Thank you for the opportunity to comment on the notice of application for the setback variance proposed by Peter Gonzales [VA-10-00004]. We have reviewed the application and have the following comments.

Re: Gonzales Setback Variance, VA-10-00004

TO: Jeff Watson, CDS  
FROM: Christina Wollman, Planner II *cw*  
DATE: April 9, 2010  
SUBJECT: Gonzales Variance VA-10-00004

SITE PARCEL PLAN  
PLAN DATE: FEB. 20, 2010

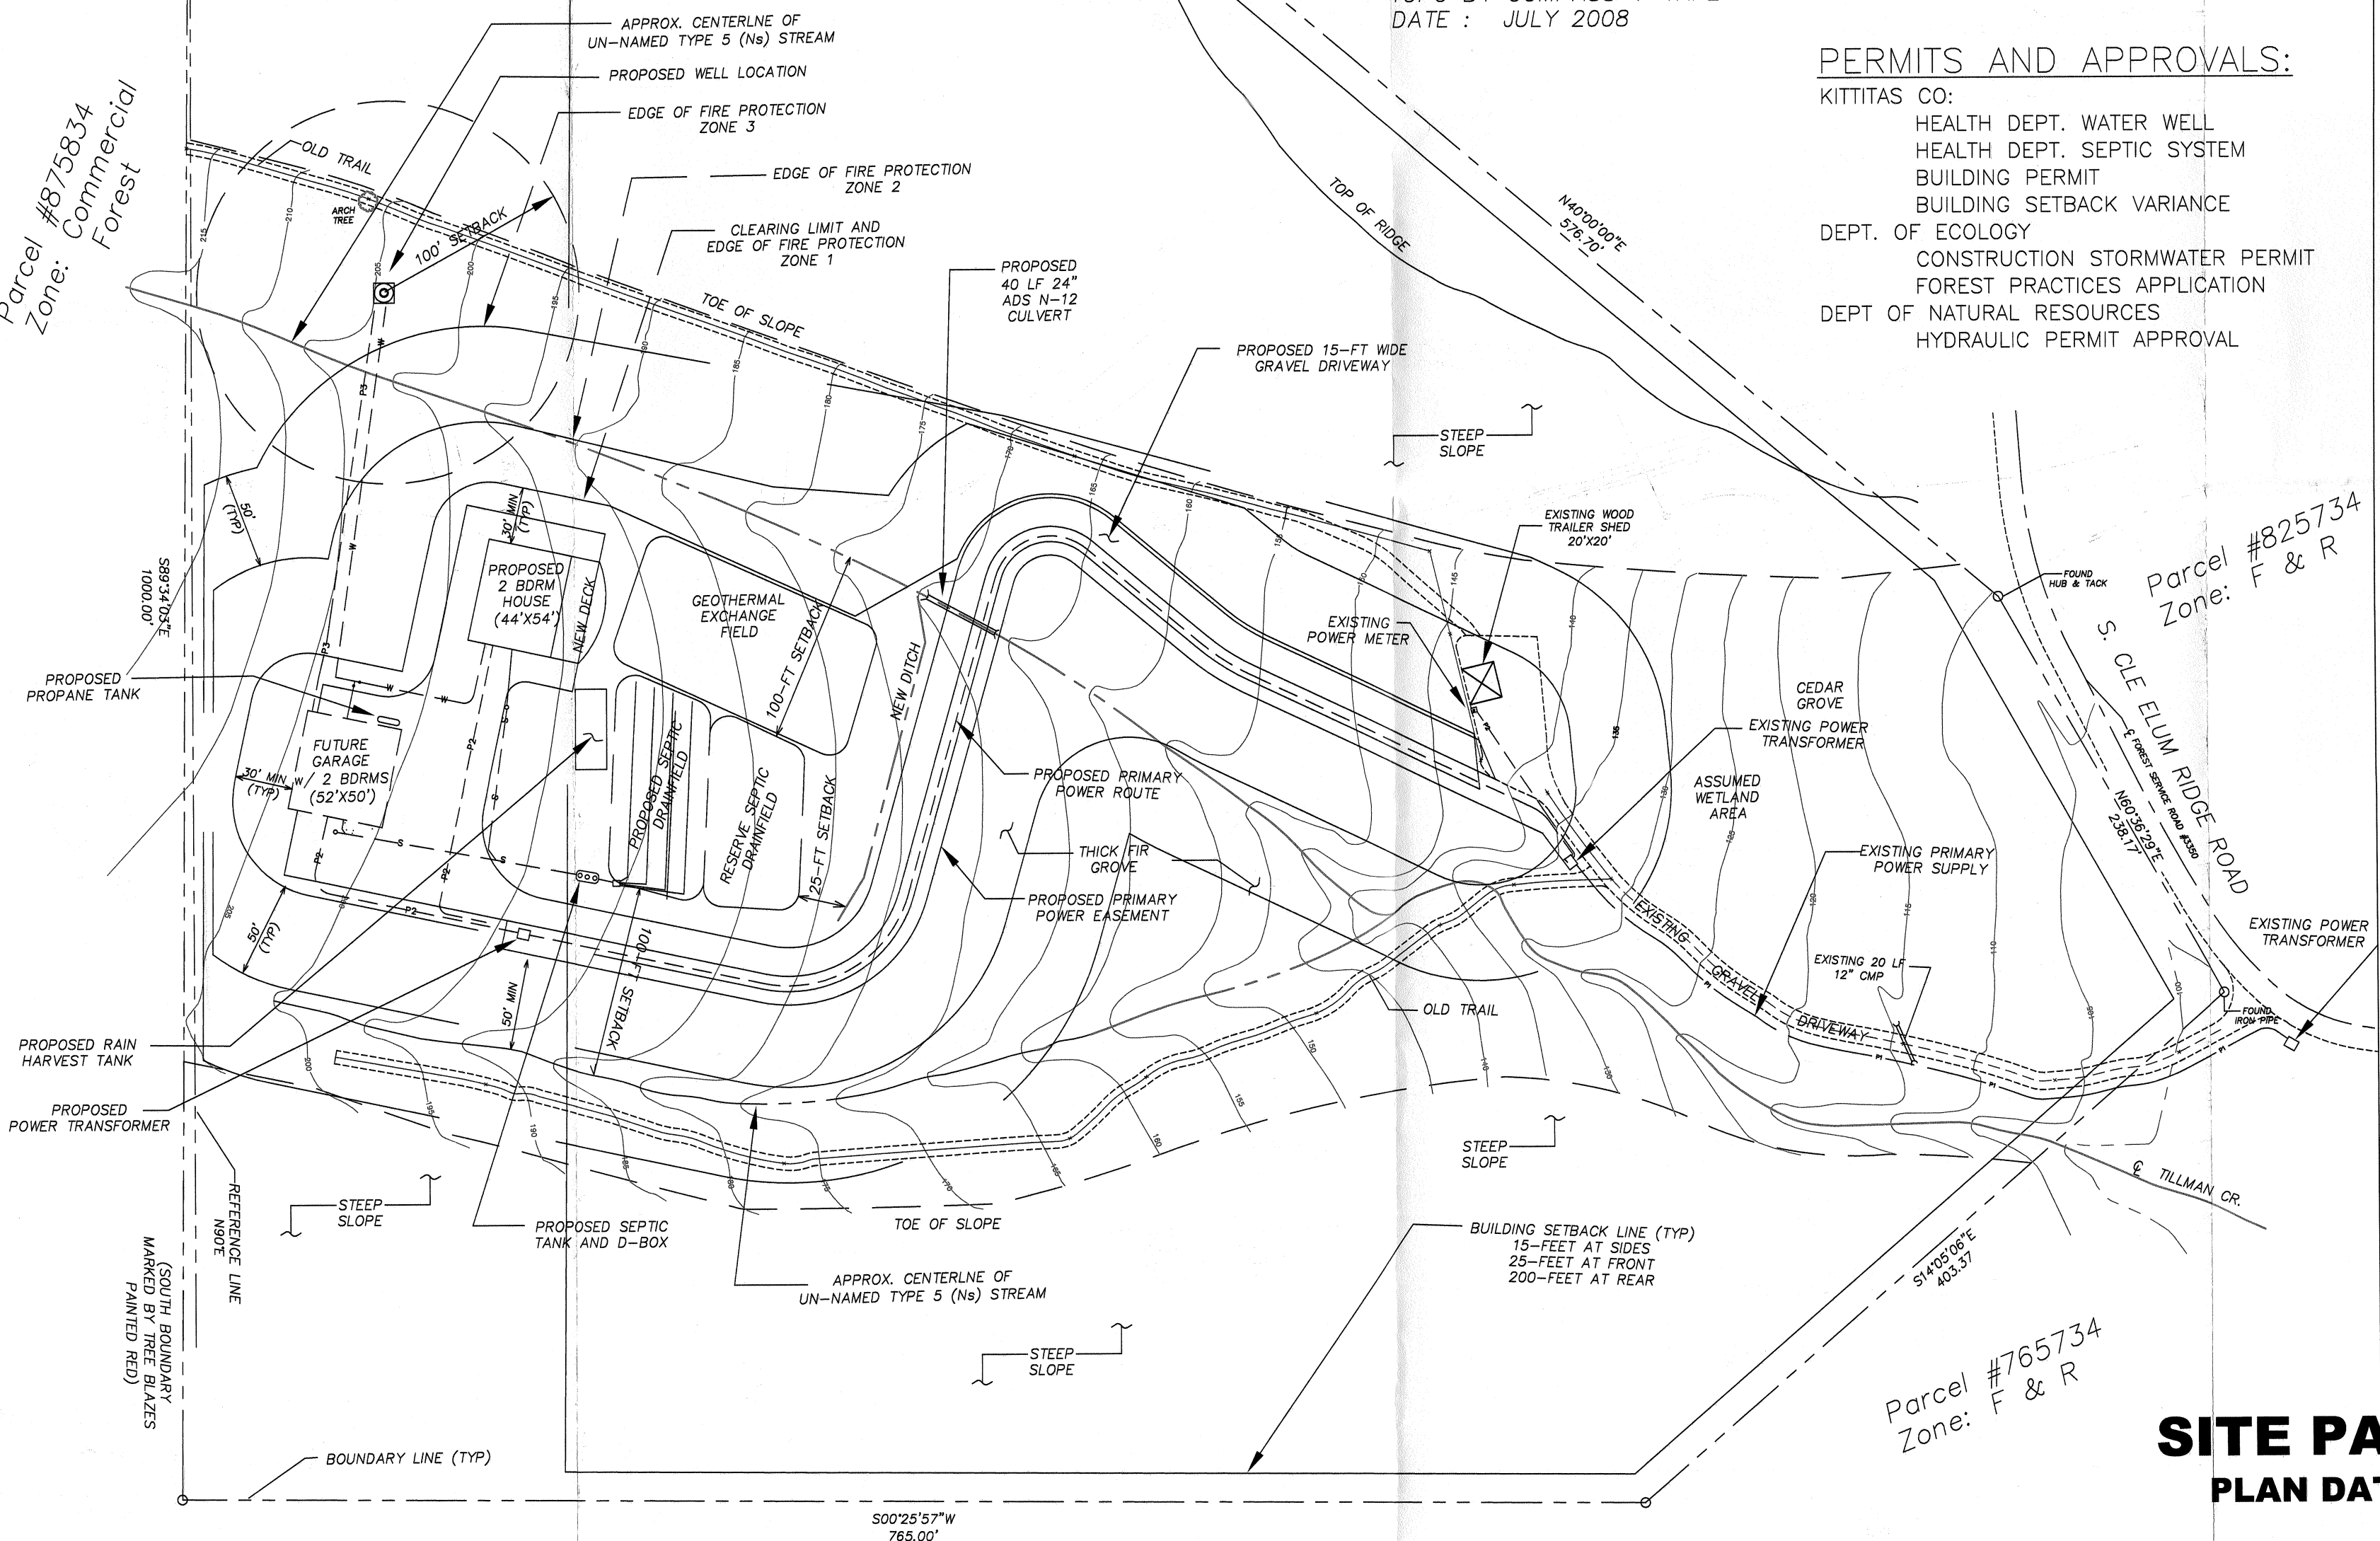
The submitted document states that there are wetlands on the north part of the property, but does not include any information on whether the existing access road is located within the wetland area, the actual extent of the wetland, nor what category the wetland is. The description of the wetlands as being comprised of cedar trees is likely to describe a wetland area that rates out at least as a category II wetland, and possibly a category I wetland. Some mitigation for potential direct and indirect wetland impacts from the proposed up-slope development may be needed if wetland hydrology is being driven by shallow water sources.

The type of geothermal exchange unit (presumably horizontal, given the space allotted in the site drawing) proposed for the site is not specified, but less space could be taken up by the system if a vertical system were installed. A vertical system would probably have less impact on the wetlands over time, assuming that wetland hydrology is originating from superficial water flows. A vertical system could be installed at the same time as the well, which could reduce staging and equipment travel costs.

A wetland delineation and rating should be completed before issuing building permits or other permits for construction of utilities, etc. The wetland characterization is needed to establish wetland background condition, so that if the proposed development will have a potential negative effect on the wetland, then appropriate mitigation measures can be required.

- All future development must comply with the International Fire Code and Kittitas County Code.
- Ensure that any structure hereafter erected does not encroach on neighboring structures, tanks, etc. It appears from the site plan submitted that the LPG tank setbacks may not be met. Ensure that appropriate setbacks are maintained.
